**Consultation Response from KC,
Highways Development Management**

2022/93938 Piazza Shopping Centre, New Street and Albion Street, Huddersfield, HD1 2TR

Change of use from A1 (business retail and storage) to C3 (residential) 34 studio flats at first and second floors and external alterations

Date Responded:13/02/23

**Accommodation Schedule**

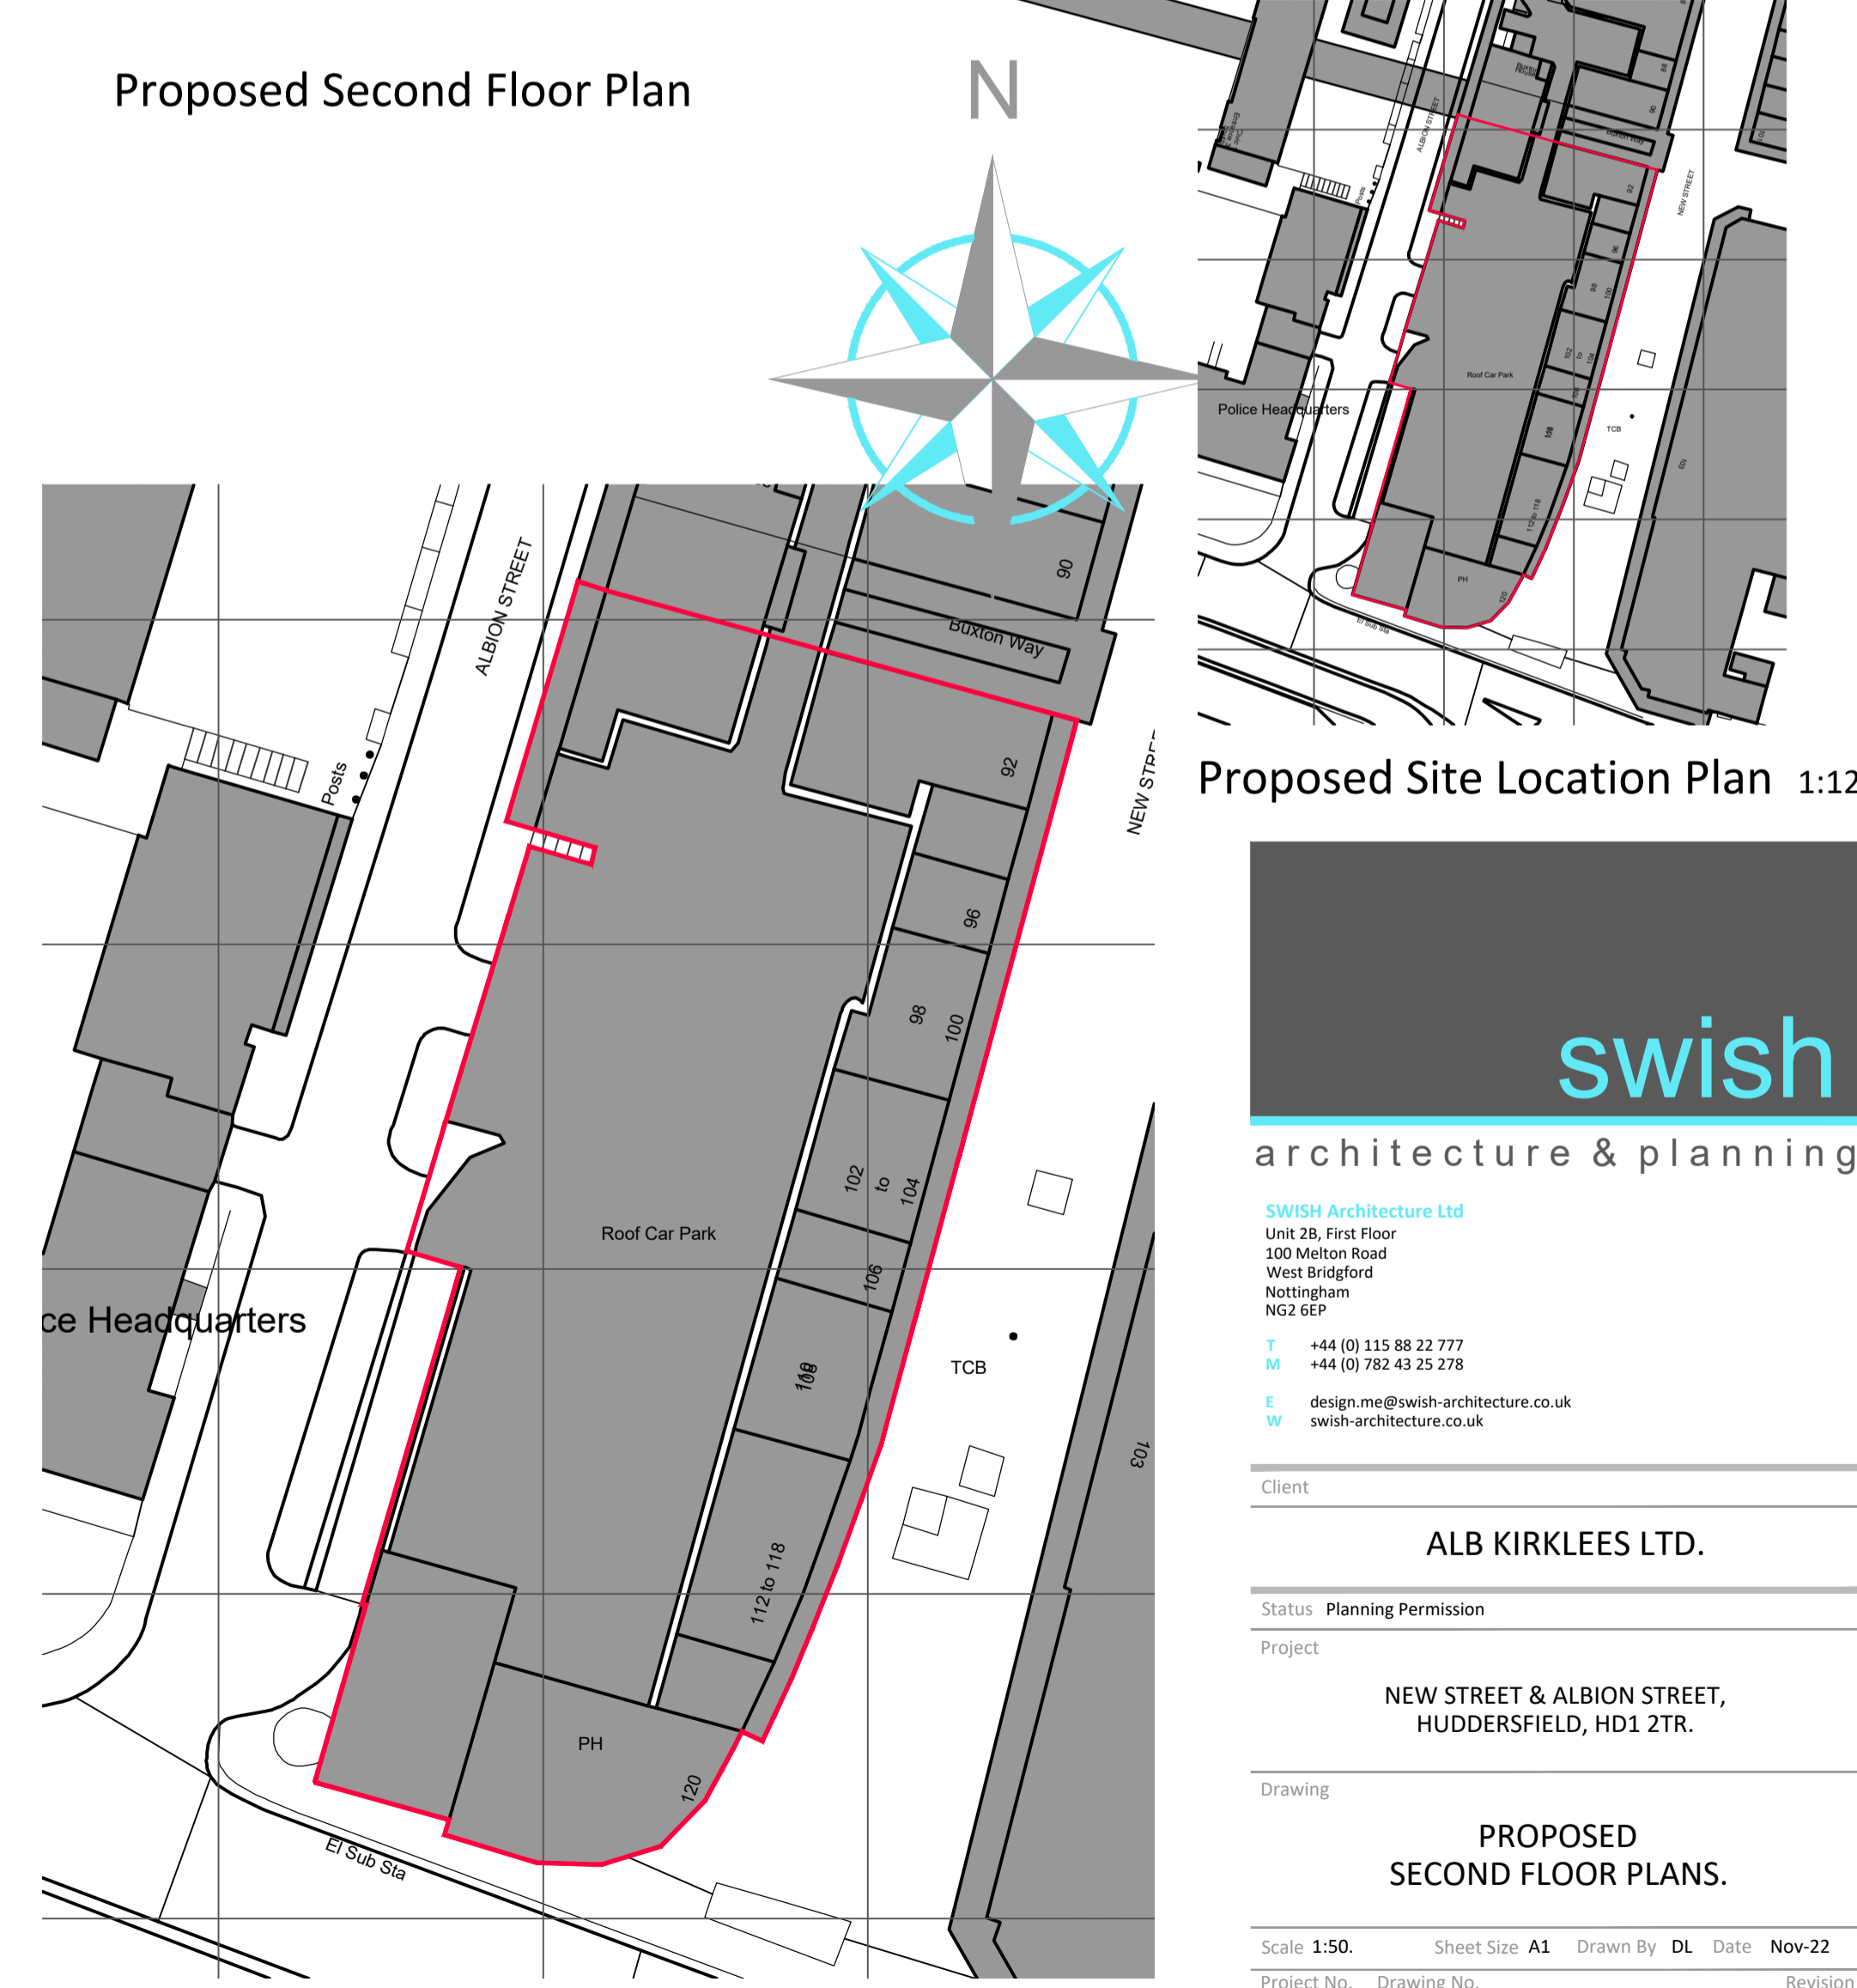
No details were provided relating to waste storage and collection beyond the mention that "ample refuse storage is also provided for the proposal, with space allocated close to the proposed development to the internal courtyard of the site" The internal courtyard is not clearly indicated on the supplied drawings and there is no indication of a route through from the proposed dwellings to any internal locations within the site. We would need to see how the waste from the proposed dwellings would be collected, including the position of a collection presentation point adjacent to a suitable adopted highway and located to follow Kirklees waste strategy guidance. This could be conditioned.

Before development commences, details of suitable storage, bin presentation points and access for collection of wastes from the dwellings hereby approved shall be submitted to and approved in writing by the Local Planning Authority. The approved details shall be provided before first occupation and shall be so retained thereafter.
